August 27, 2025

Robert Webb & Jolene Wolfley
Development Facilitation Team
City of Albuquerque
Albuquerque, NM

**RE: Applications PR-2023-008710 & SI-2025-00082
U-Haul Site Plan Comments/Responses #2
8200 Jefferson St NE, Albuquerque, NM**

SHEET CONTENTS:
**ALTERNATIVE
RESTORATION
PLAN**

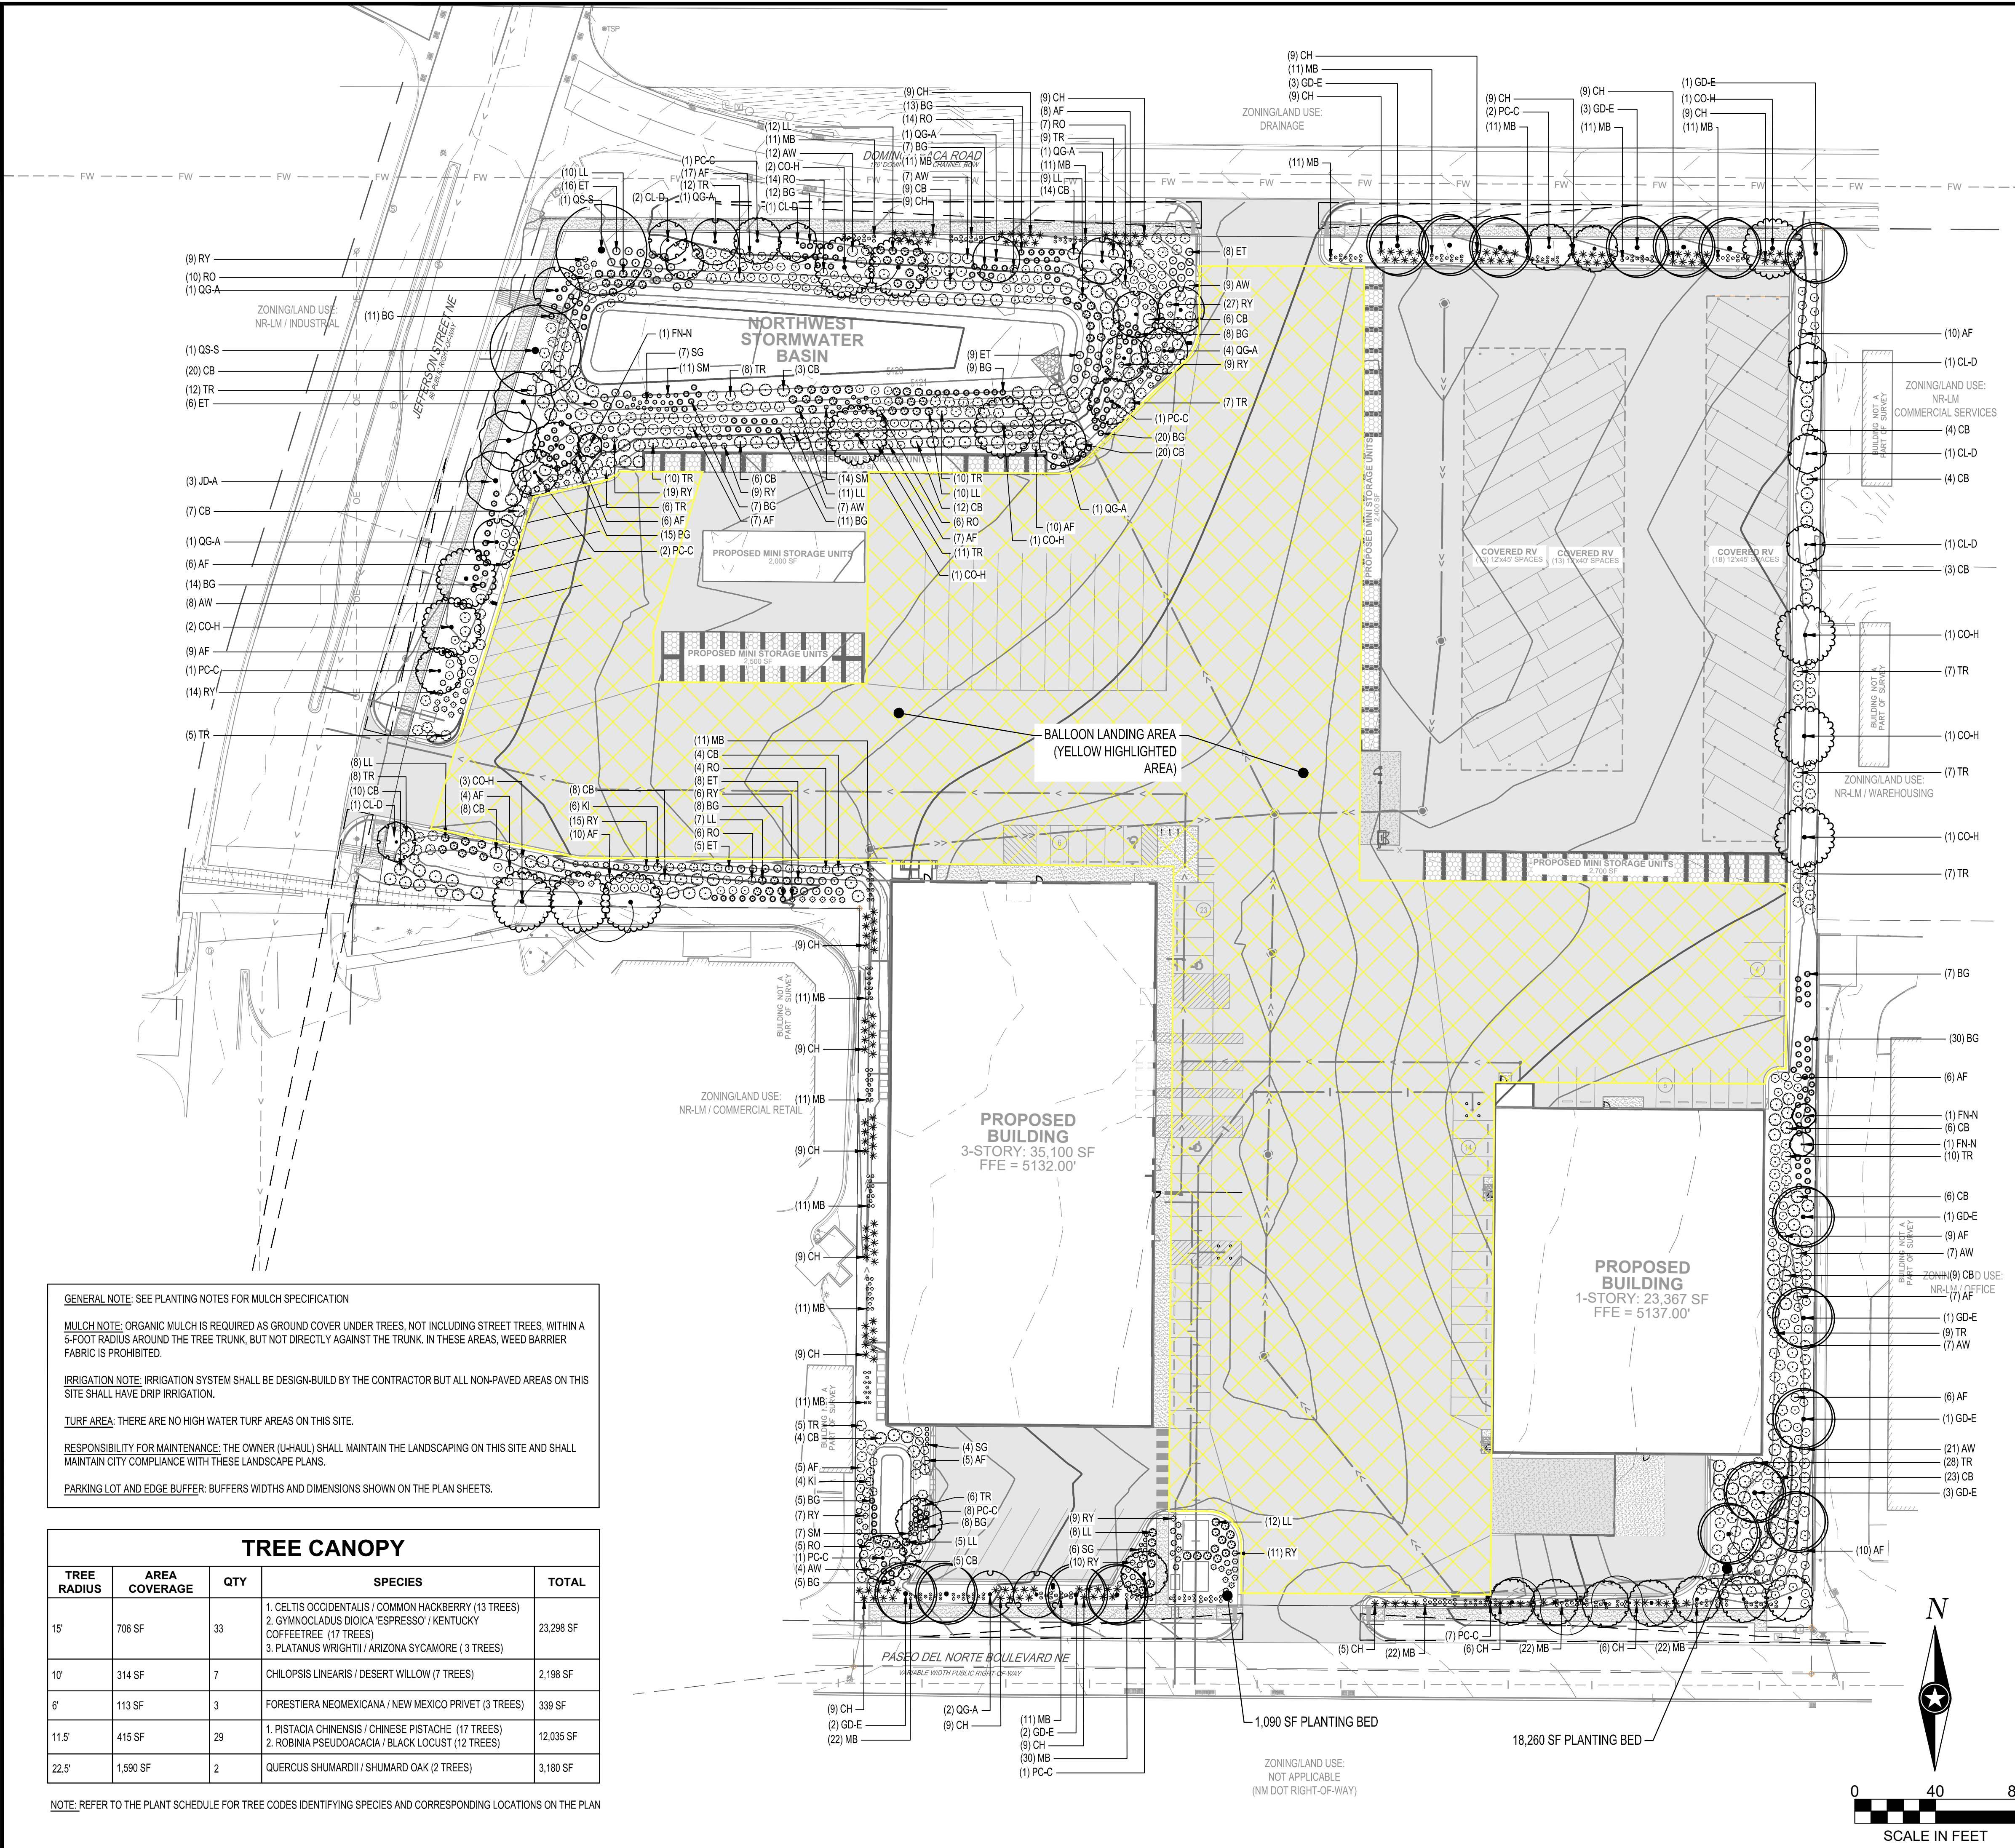
- 1. Replace grey Oak with larger deciduous tree

- 2. Alligator Juniper is listed as a street tree. Per Parks and Recreation, the Alligator Juniper, will need to be replaced with something deciduous capable of reaching a mature canopy for shade purposes.

- 3. Relocate some trees from north to stormwater basin area

2. It was requested to provide the mature tree canopy calculations on the landscape sheet. Please label which trees are included in this canopy math.

ISG Response: Grey oak has been replaced with a larger deciduous

ISG Response: Alligator Juniper has been replaced with a deciduous canopy tree

ISG Response: Trees have been relocated to the stormwater basin area.

ISG Response: Trees have been identified in the Mature tree canopy calculation table as well as the tree radius for each species has been identified the Plant Schedule. Please revise the plant schedule for tree codes identifying each species and their locations on the plan.
